Your ref: MP 06_0143 MOD 4
Our ref: (1515900PN and 0631/08DA)

**Response to Proposed Modification MP 06_0143 MOD 4 – Glades Estate
Lots 1 and 2 DP 725785, Pacific Highway, Moonee Beach**

WATER RETICULATION CONCEPT PLAN

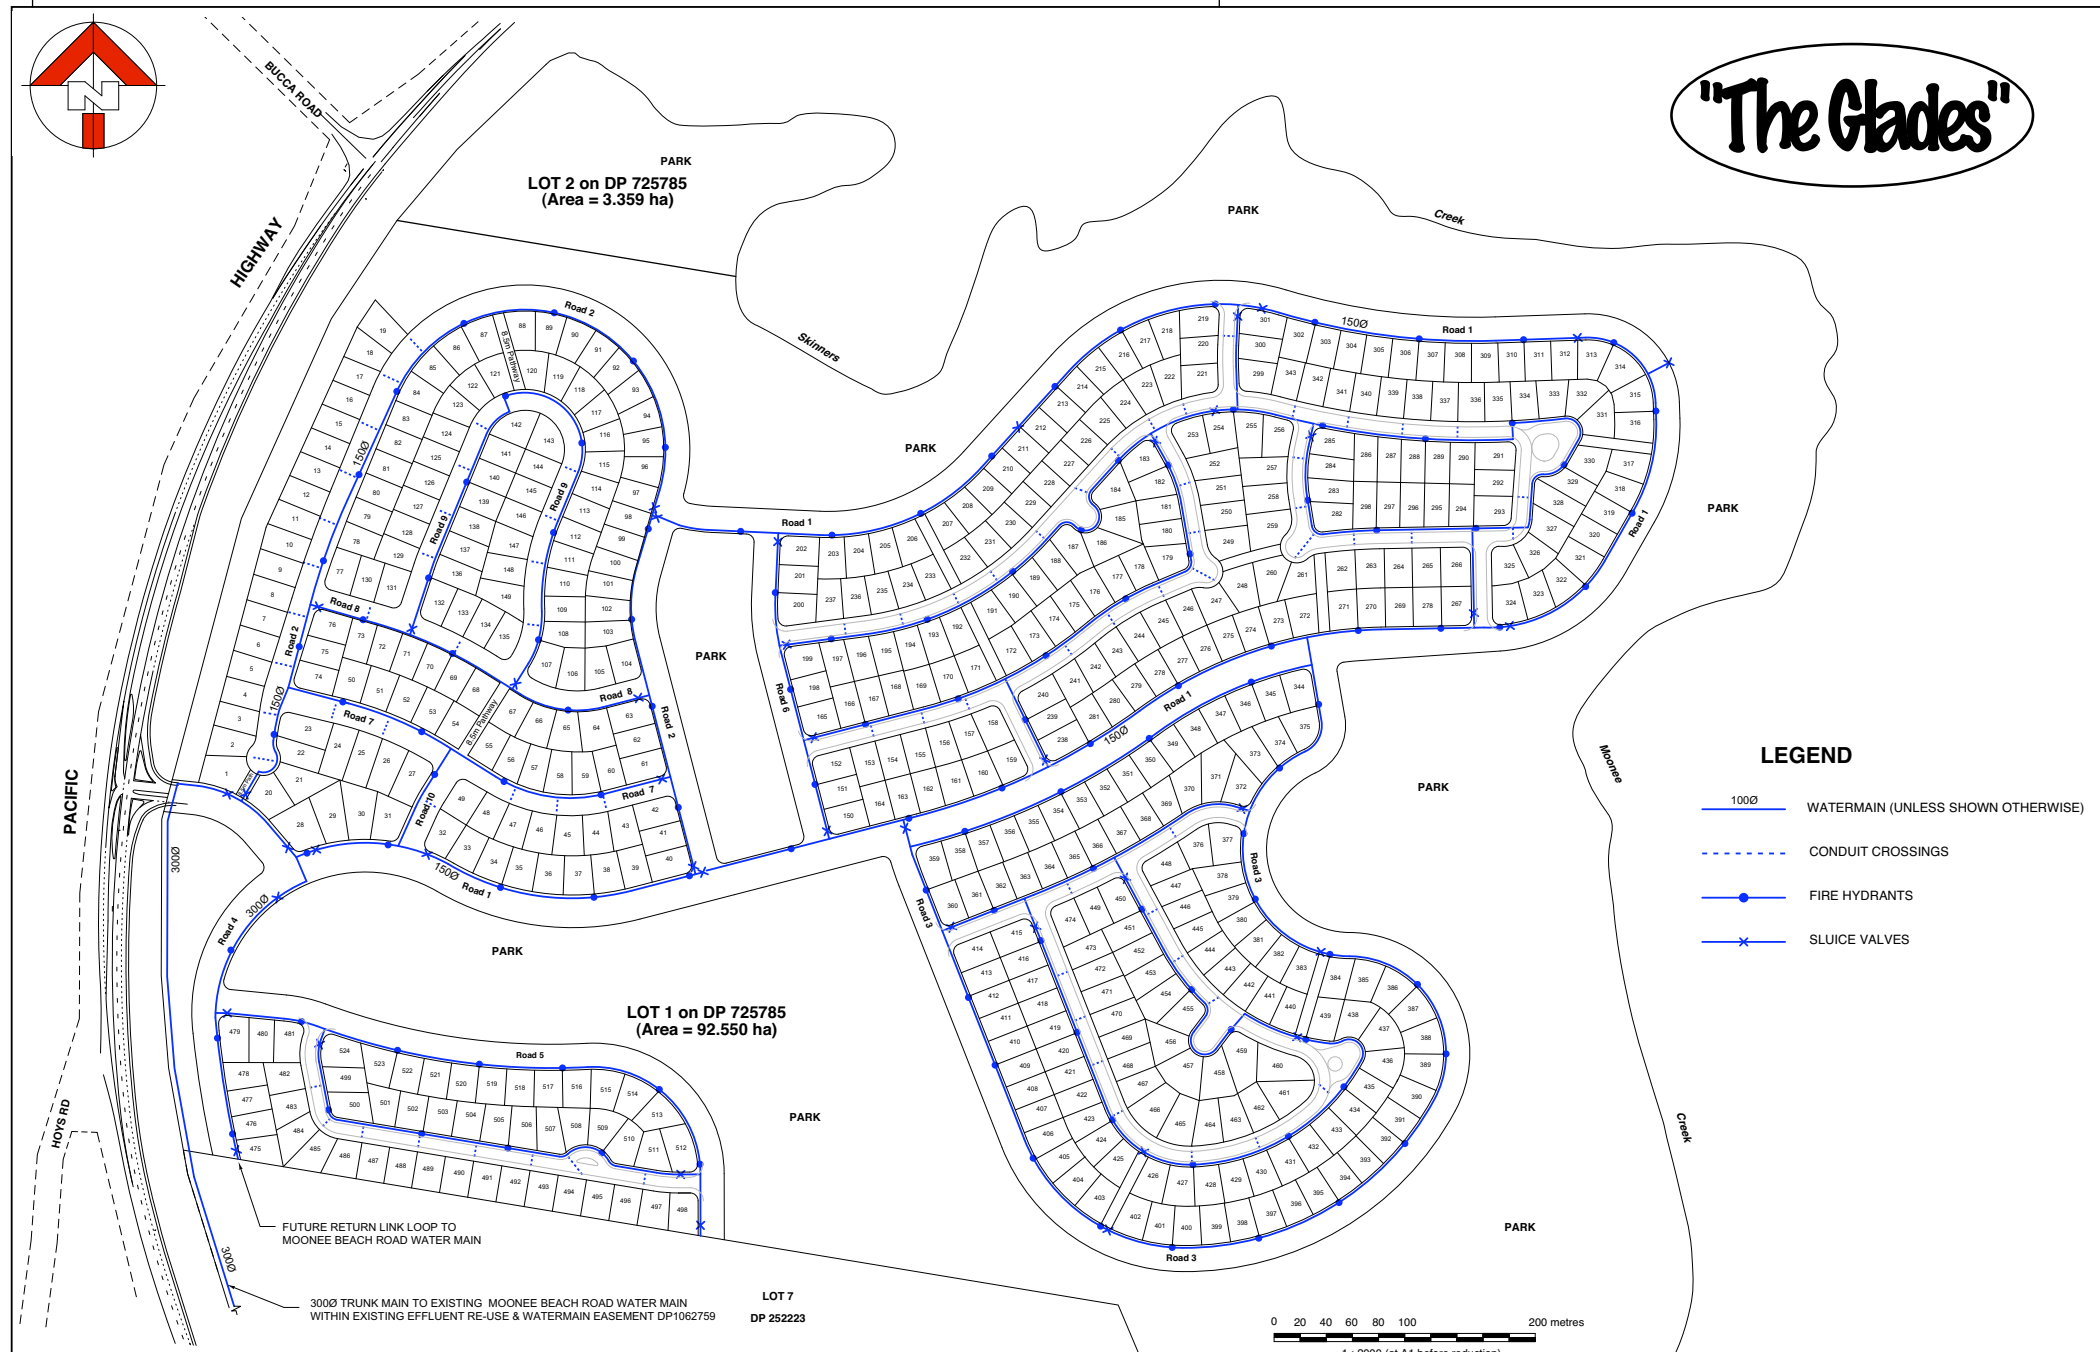
- The location of a number of the sewer pump station appears to be located in flood impacted land and below the 1% AEP flood event. Sewer pump stations are required to be located above the 1% AEP level. Council recommends that the Department ask the applicant to amend the bulk earthworks plan to address this and any associated impacts of increased fill extents (it is also noted that the designated sewer pump station and bio-retention areas appear to be conflicting. See plans referenced in Condition A3 prepared by AusPacific Engineers drawing number P5 rev. C 'Stormwater Drainage and Catchment Plan' April 2008 and P7 rev A 'Conventional Sewerage Reticulation Concept Plan' April 2008).

1% AEP FLOOD EVENT INUNDATION EXTENT (DEVELOPED)

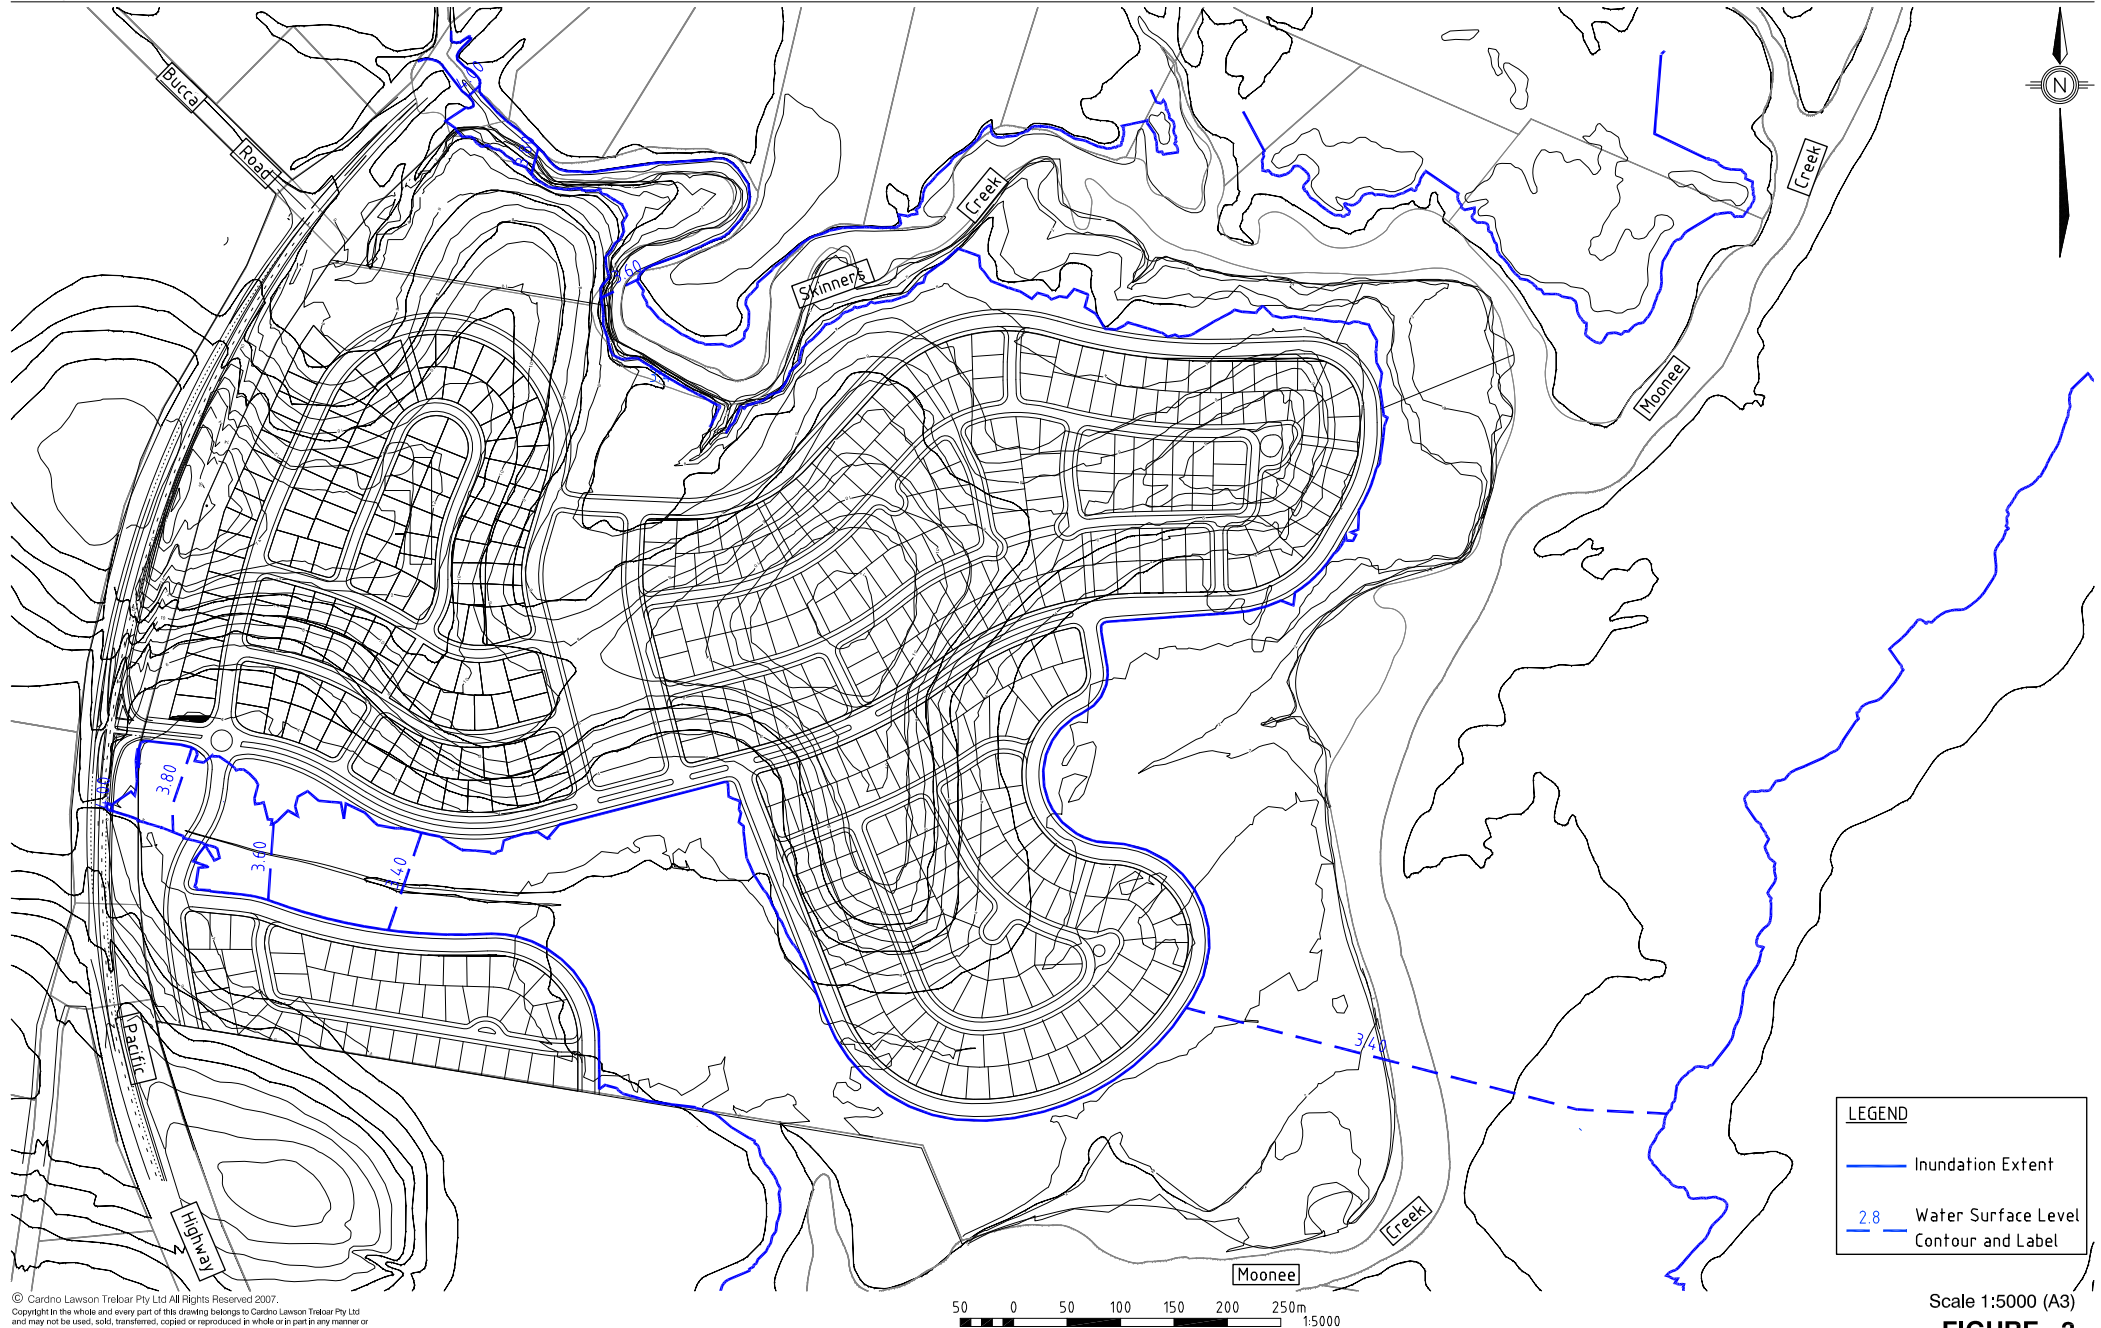
- From a flooding perspective, there is no objection to the removal of the second sentence in condition E16, as stated.
- Council requests that a condition be imposed requiring that a copy of the flood model result files be provided to council prior to the issuing of subdivision certificate (for the purposes of applying flood planning level to individual lots in the future).

- Council requests that a condition be imposed that requires a restriction be created on the title of the lots affected by the 1% AEP, restricting the use of this portion of the lot for any habitable building or structure
